Addendum No. 2

RE: Contract # C204507

Cumberland County (U-5798A)

SR-1102 FROM NORTH OF SR-1112 TO US-401 AND REPLACE BRIDGE
250075 OVER LITTLE ROCKFISH CREEK.

POUR #2
UPPER PART OF WINGS AND BACKWALL 17.8 C.Y.

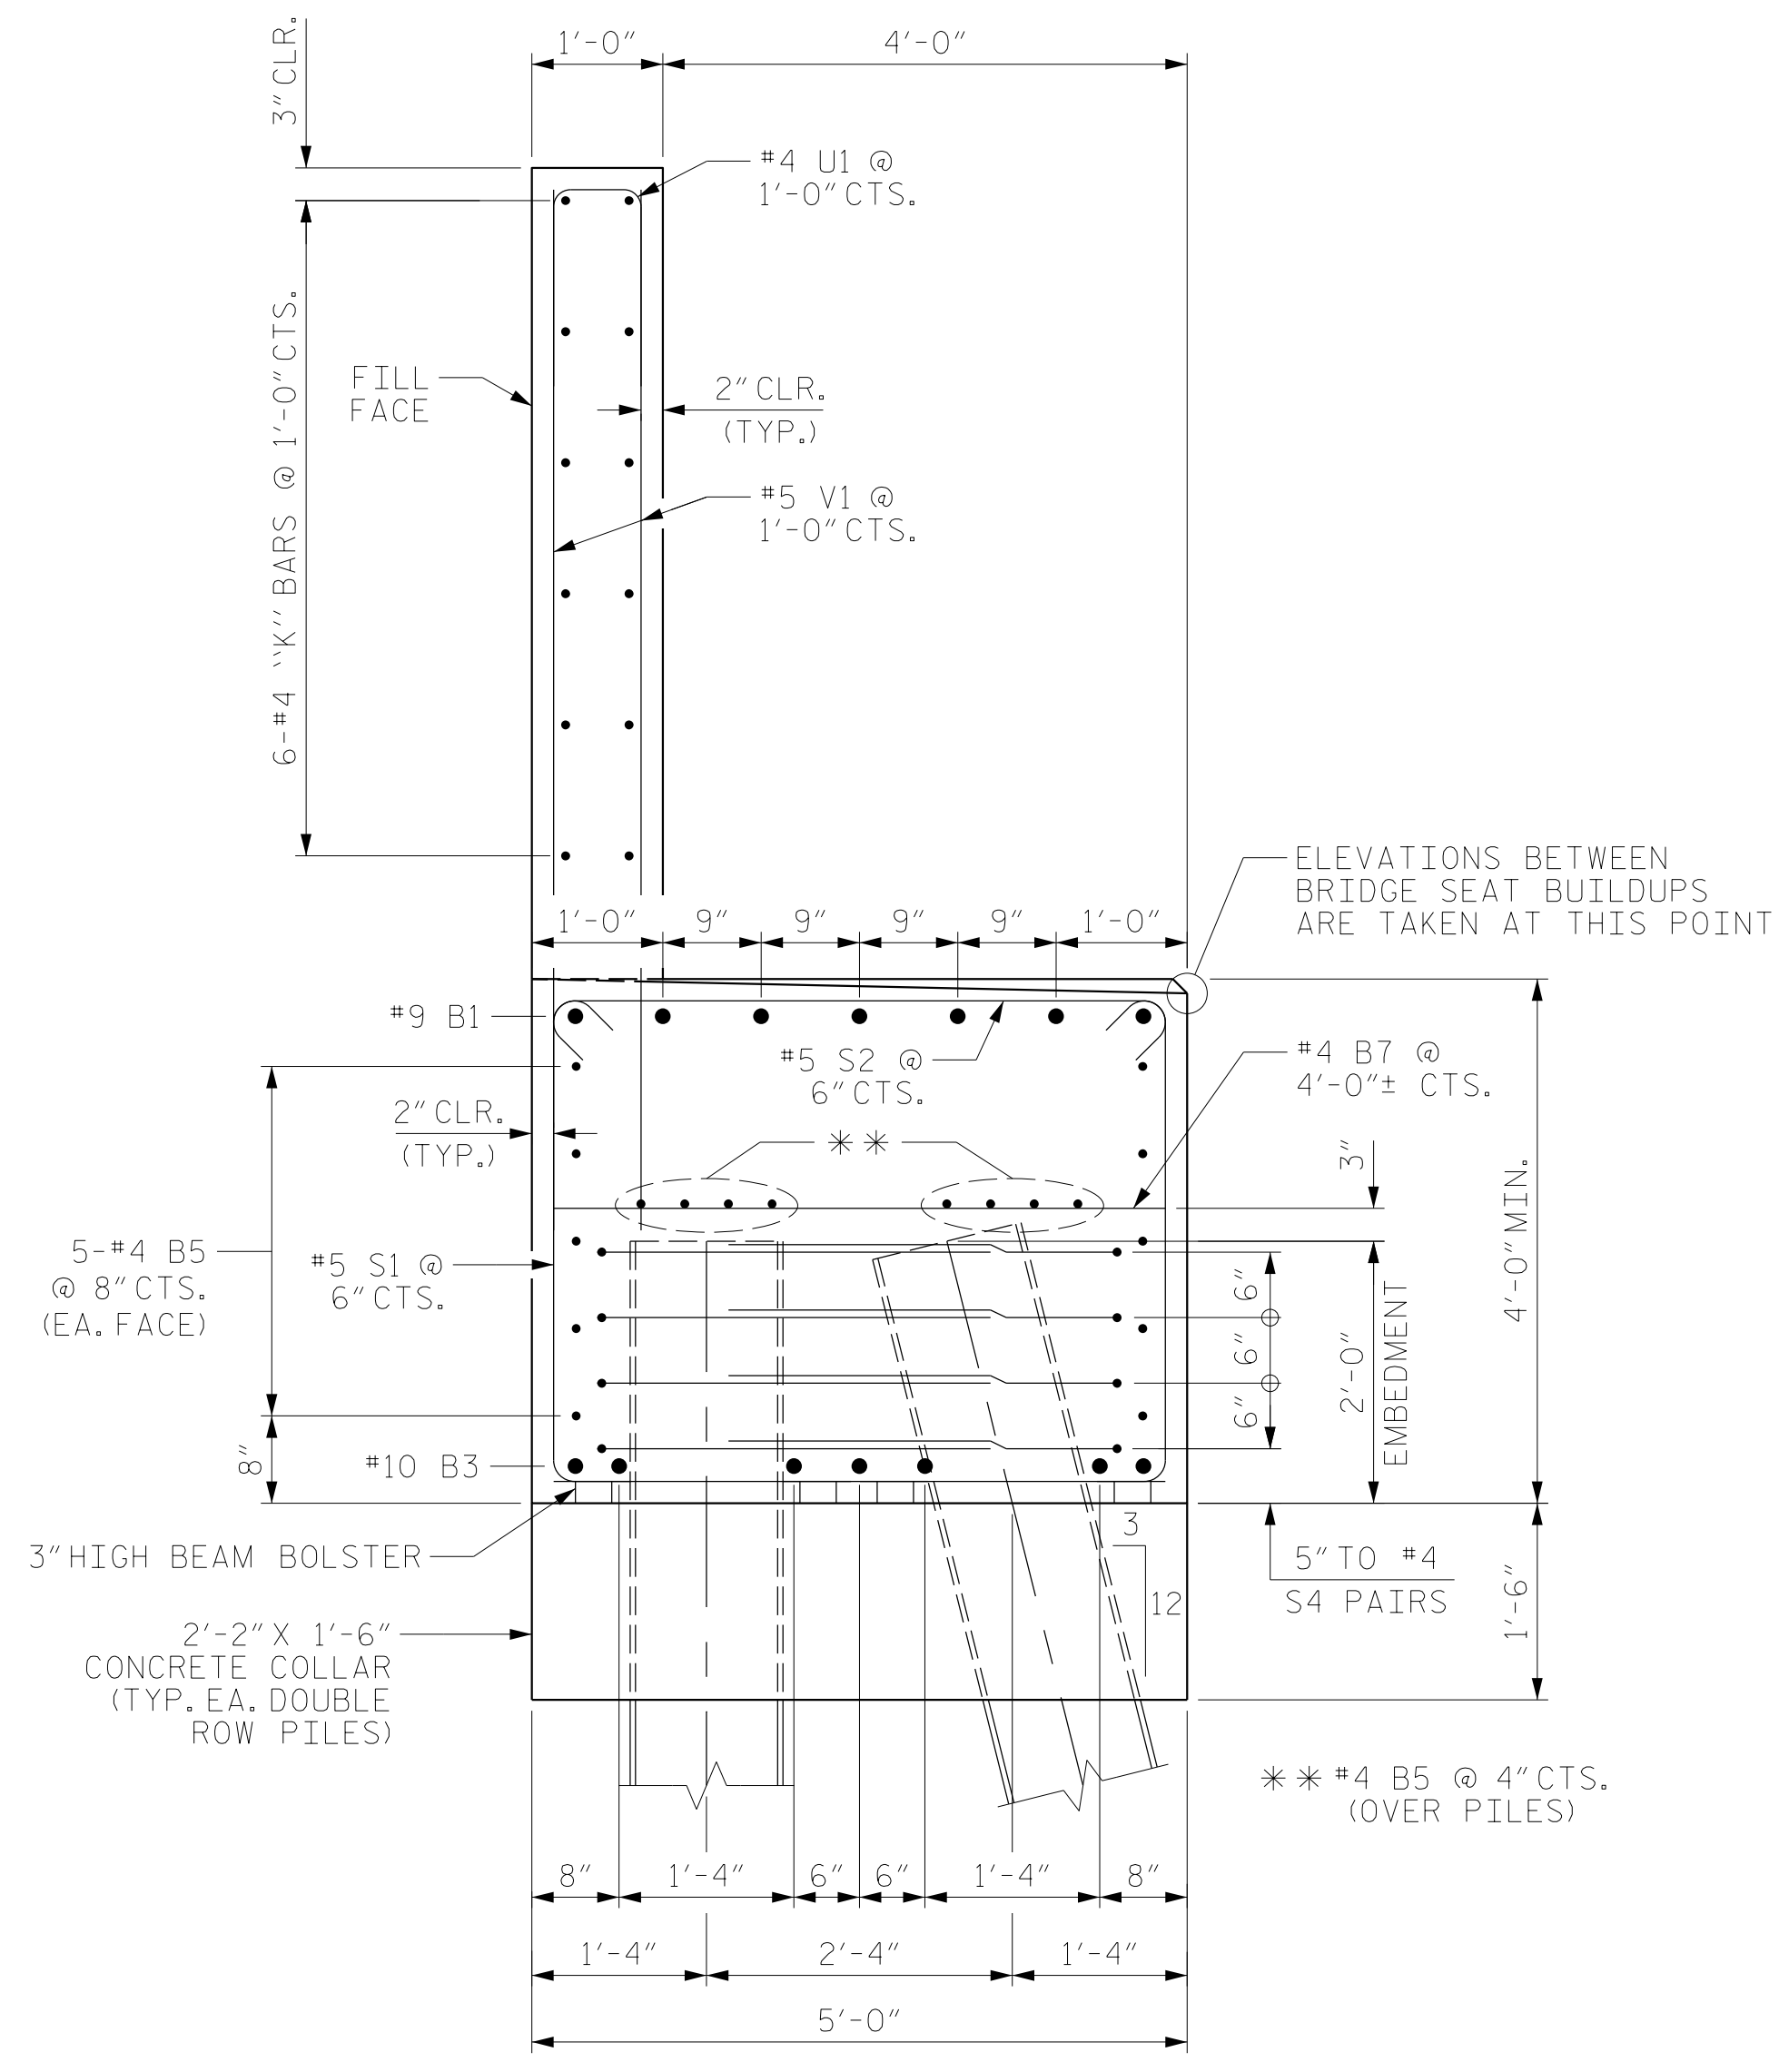
Sheet No.	Revision
S1-3	Updated to reflect quantity changes.
S1-33	Updated to reflect quantity changes.
S1-39	Updated to reflect quantity changes.
S2-3	Updated to reflect quantity changes.
S2-33	Updated to reflect quantity changes.
S2-39	Updated to reflect quantity changes.

<u>Item</u>	<u>Description</u>	<u>Old Quantity</u>	<u>New Quantity</u>
0240-8328200000-E-450	PILE DRIVING EQUIPMENT SETUP FOR HP 14 X 73 STEEL PILES	40 EA	44 EA
0242-8384000000-E-450	HP 14X73 STEEL PILES	2,580 LF	2,840 LF
